**A1 Birtley to Coal House**  
**Scheme Number: TR010031**

**Applicant's Response to ExA's Fourth Written**  
**Questions**

**Applicant's Response to ExA's  
Fourth Written Questions**

<b>Version</b>	<b>Date</b>	<b>Status of Version</b>
Rev 0	13 July 2020	For Issue

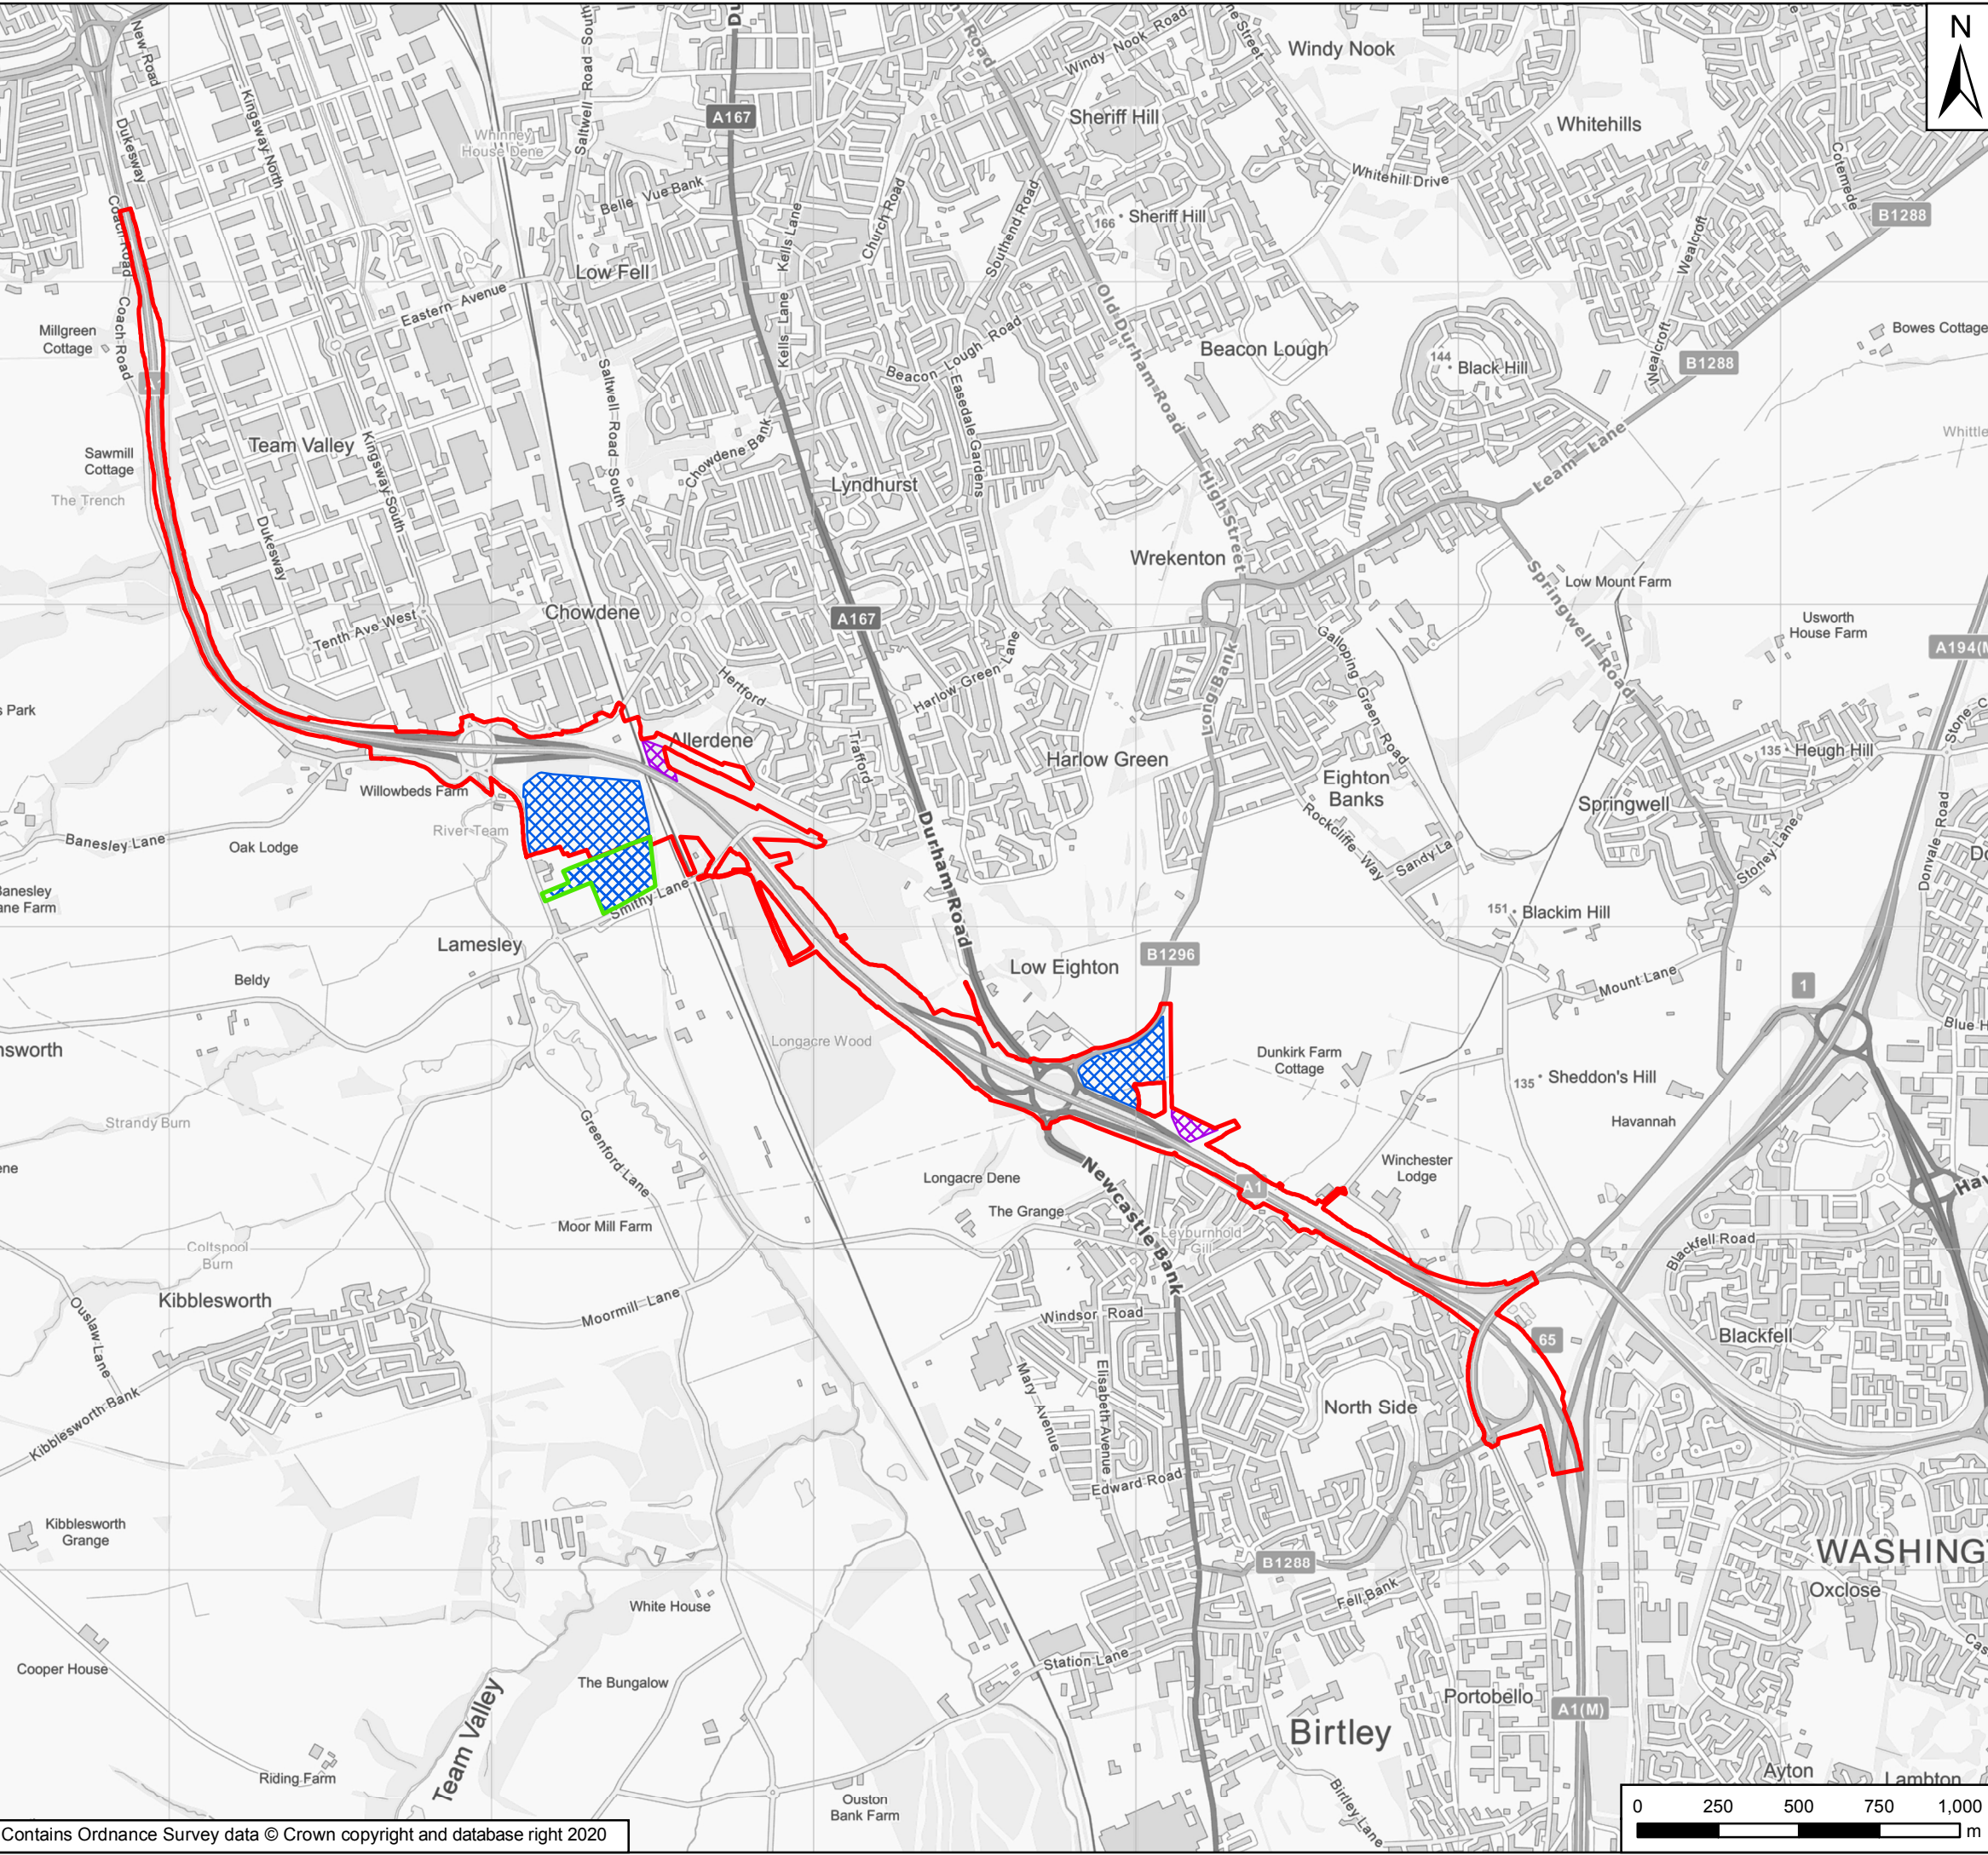
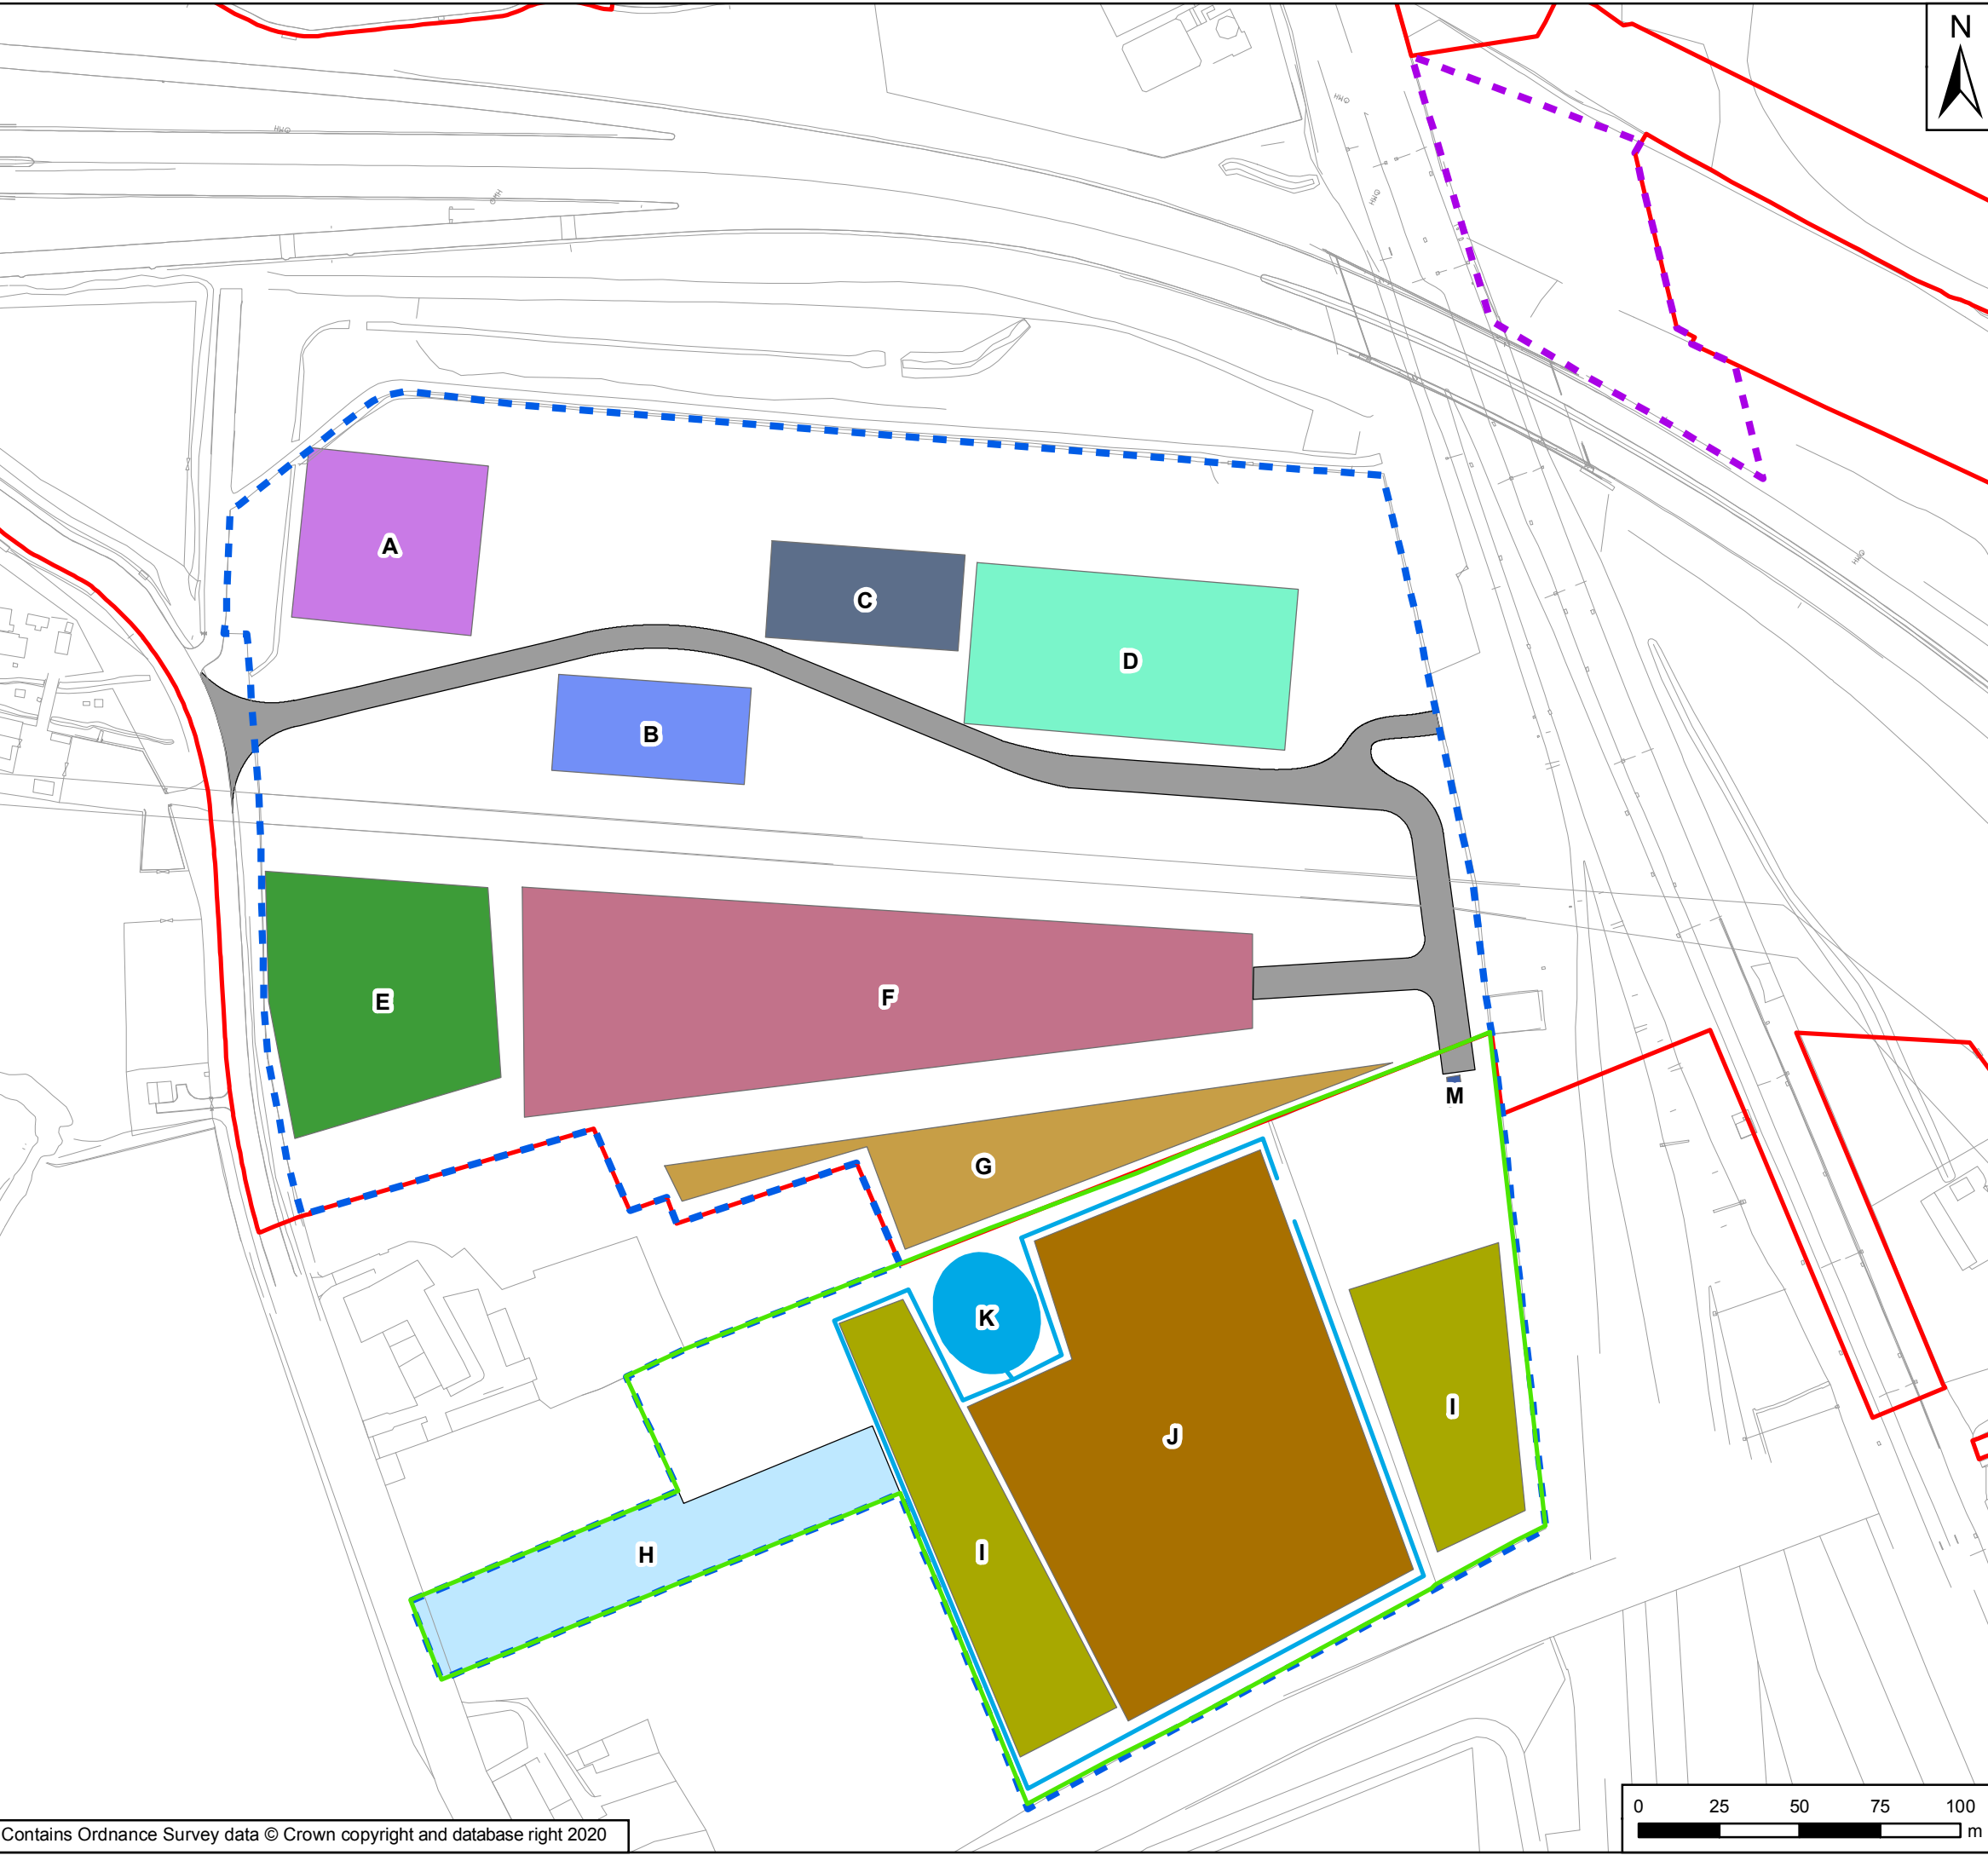
Ex Q4:	Question to:	Question:	Applicant's Response:
4.1.1	Applicant	<p>Figure 1/AI Site Compound Plan Detailed View, Junction 67 (Additional Land) of Appendix A of the Construction Environmental Management Plan [REP8-007] shows what appears to be areas of spare (white) space with the northernmost part of the compound, with no designated use. Given the amount of space that appears not to be required for any designated use or purpose within the compound, how can the Secretary of State be satisfied that the amount of land proposed to be acquired is no more than is reasonably required?</p>	<p>The absence of a designated use is not evidence of the absence of use for the land in question. It is the Applicant's case that all land within the Order limits is required for the delivery of the Scheme. It may comprise working areas or circulation space.</p> <p>The "white space" that the ExA has identified is necessary for the delivery of the Scheme as a whole. In the first instance, the land in question will be used for the delivery of Work No 12, being the replacement installation for Northern Gas Networks (NGN). The works in question would either be used by NGN itself or by the Applicant to deliver those works.</p> <p>When the main works are programmed to commence, that part of the site is likely to be required for the NGN works for some seven months thereafter. That part of the site will essentially be sterile and the Contractor implementing the Scheme on behalf of the Applicant will not be able to use it when works start. It will then be used to facilitate access to construct the new embankment/bridge and for storage.</p> <p>The proposed arrangement of temporary cabins, welfare parking, temporary plant and material located between the existing overhead 66kV power lines and the existing 900mm dia trunk water main also allows space to construct the proposed CNG terminal. On the plan, exclusion zones around the overhead service are shown as set out in GS6 of the Register of Environmental Actions and Commitments (REAC) in the Construction Environmental Management Plan (CEMP) [REP9-007 and 008] for working in close proximity of overhead lines.</p> <p>Therefore, when the programme of works for both the NGN diversion and above ground installation (Works No.9, 10, 12 to 16) and the construction of the highway elements of the Scheme are considered together, there is no 'white space' for the first seven months and that whole area will be occupied by either NGN or the Contractor implementing the Scheme on behalf of the Applicant.</p> <p>Once the NGN diversion is complete, the area in question will no longer be required and some of it, south of the track, would potentially be returned to pasture land. It is entirely reasonable to seek powers over the maximum area of land required because the construction sequence has been planned out so that both works for NGN and the A1 highway can be delivered to programme in compliance with CDM Regulations.</p> <p>There is no need for additional wording in the DCO to address this. It is appropriate to enable the Scheme to be delivered to include the whole of the land in question.</p>
